## Application for a Non-Material Amendment Following a Grant of Planning Permission

## Non-Material Amendment(s) Sought

5 Alverley Close

client Nigel & Louise Sharratt	status BUILDING REGULATIONS		
	 Tel: 07834 206207 email: camilla@architectureventures.com		
project 5 Alverley Close, Copthorne, Shrewsbury SY3 8LS	scale 1:50 @ A1	date 22/11/2023	drawn JE
	drawing New Bungalow Proposed Layout PLANS	drawg no AC101	rev G

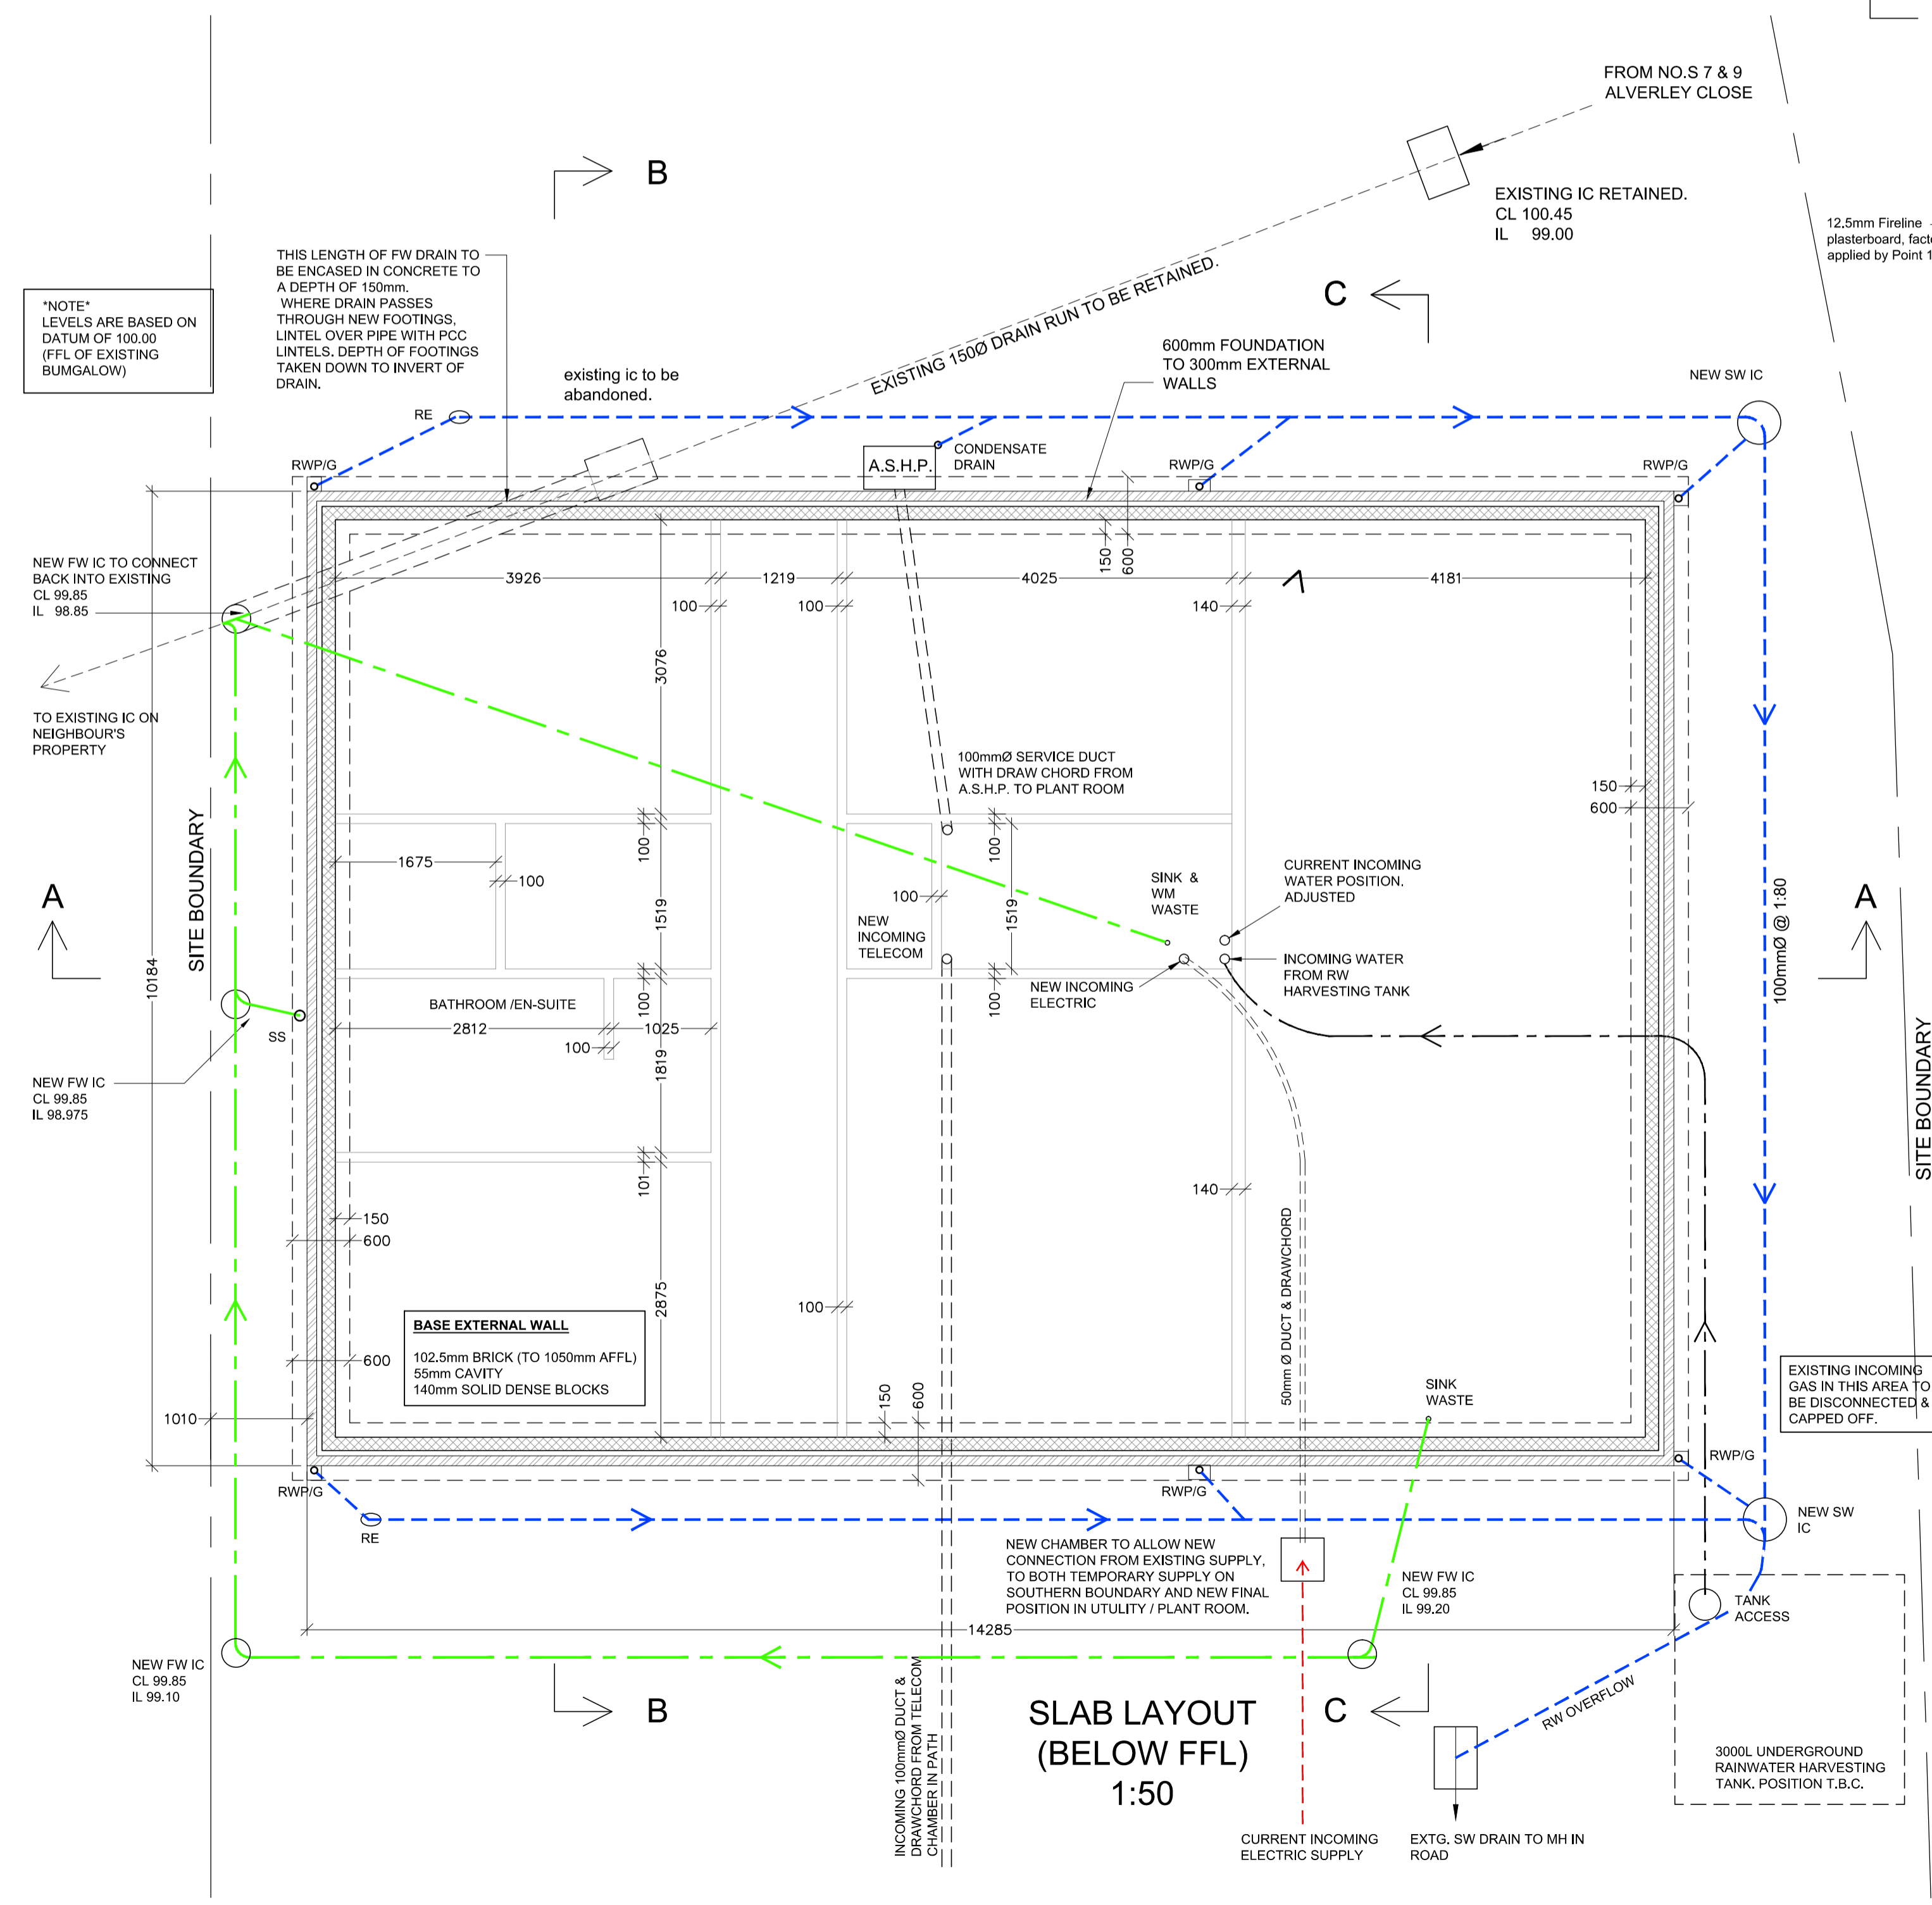
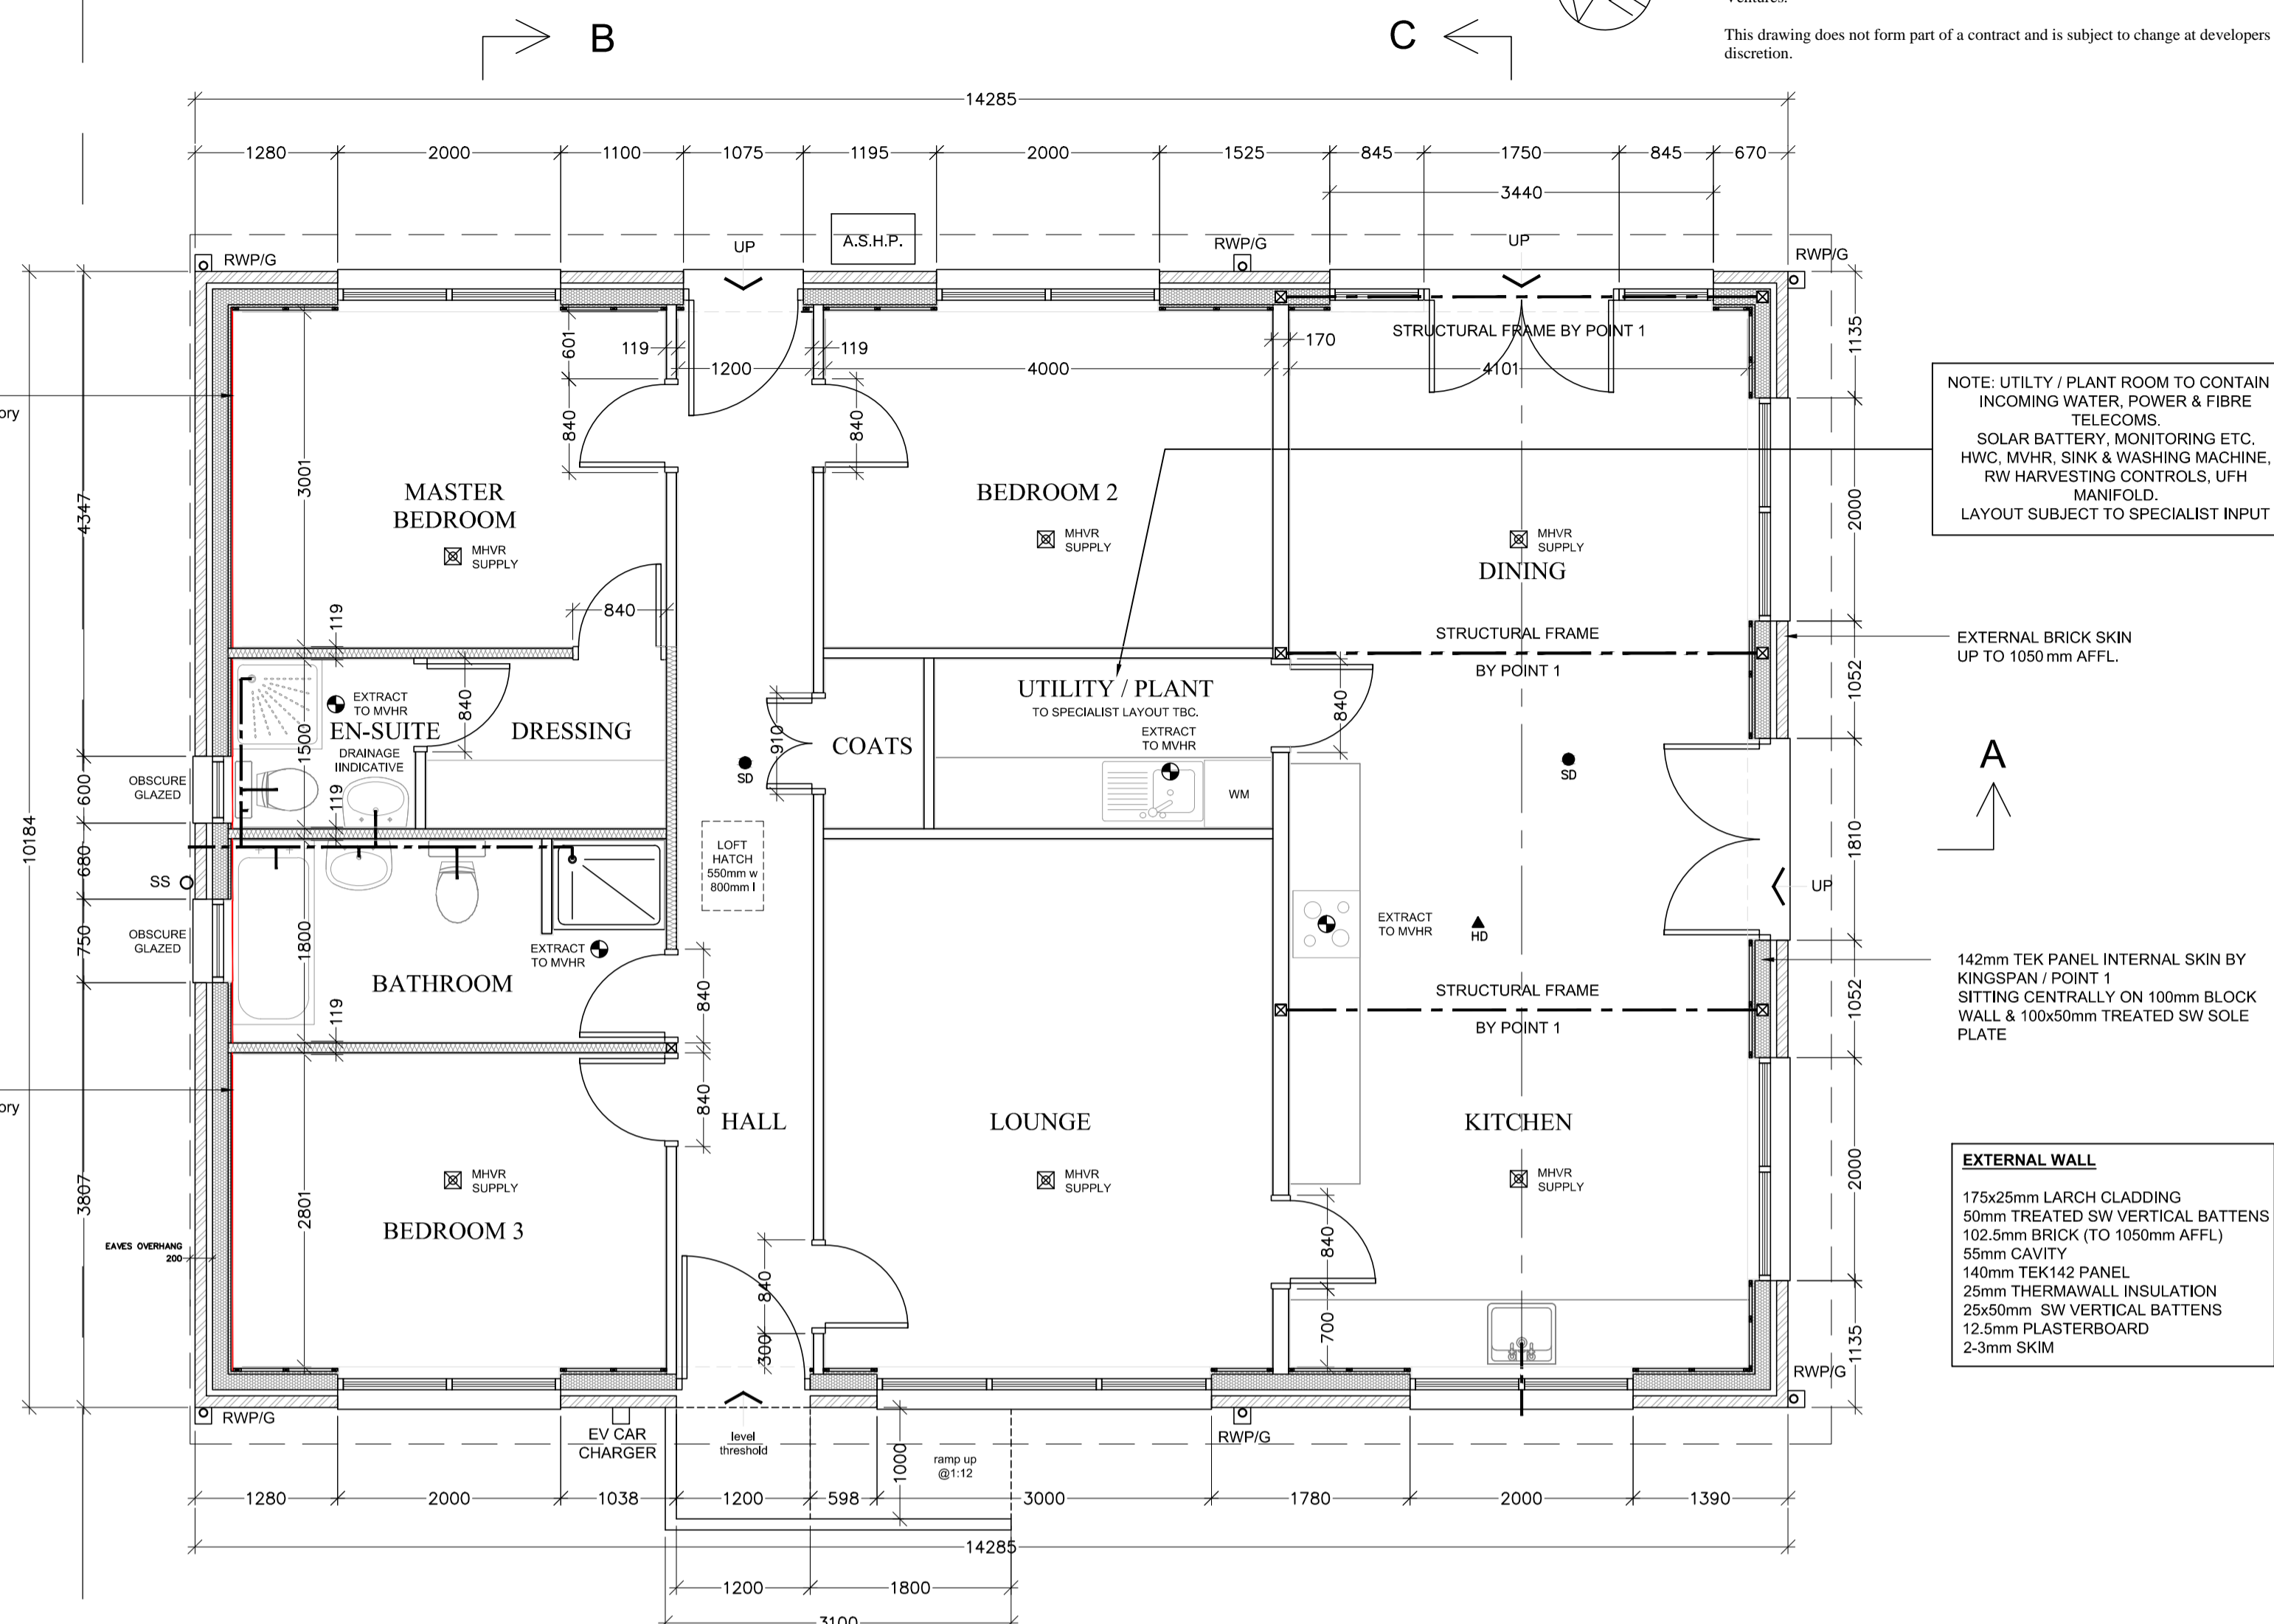
The existing building had a wall entirely of brick and was about 0.5 metre from the boundary at its closest. Our planning approval proposed to increase this distance to a minimum of 0.75 metres and the wall was specified as larch cladding above a base of bricks up to 1 metre from ground.

The wall includes 1.5 square metre of window/glass.

The larch cladding and window don't meet the Building Regulations B4 External Fire risk requirement, so to mitigate this risk Approved Inspectors Ltd have agreed for us to move this wall (and the whole building) a further 0.26 metres to the south to make the wall 1.01 metres from the boundary with No 3. This has no impact on the south elevation as there is space for this.

Building Control Approved Inspectors Ltd have raised an issue of Fire Risk B4 External spread of fire with the proposed position of the north wall (and therefore the whole building).
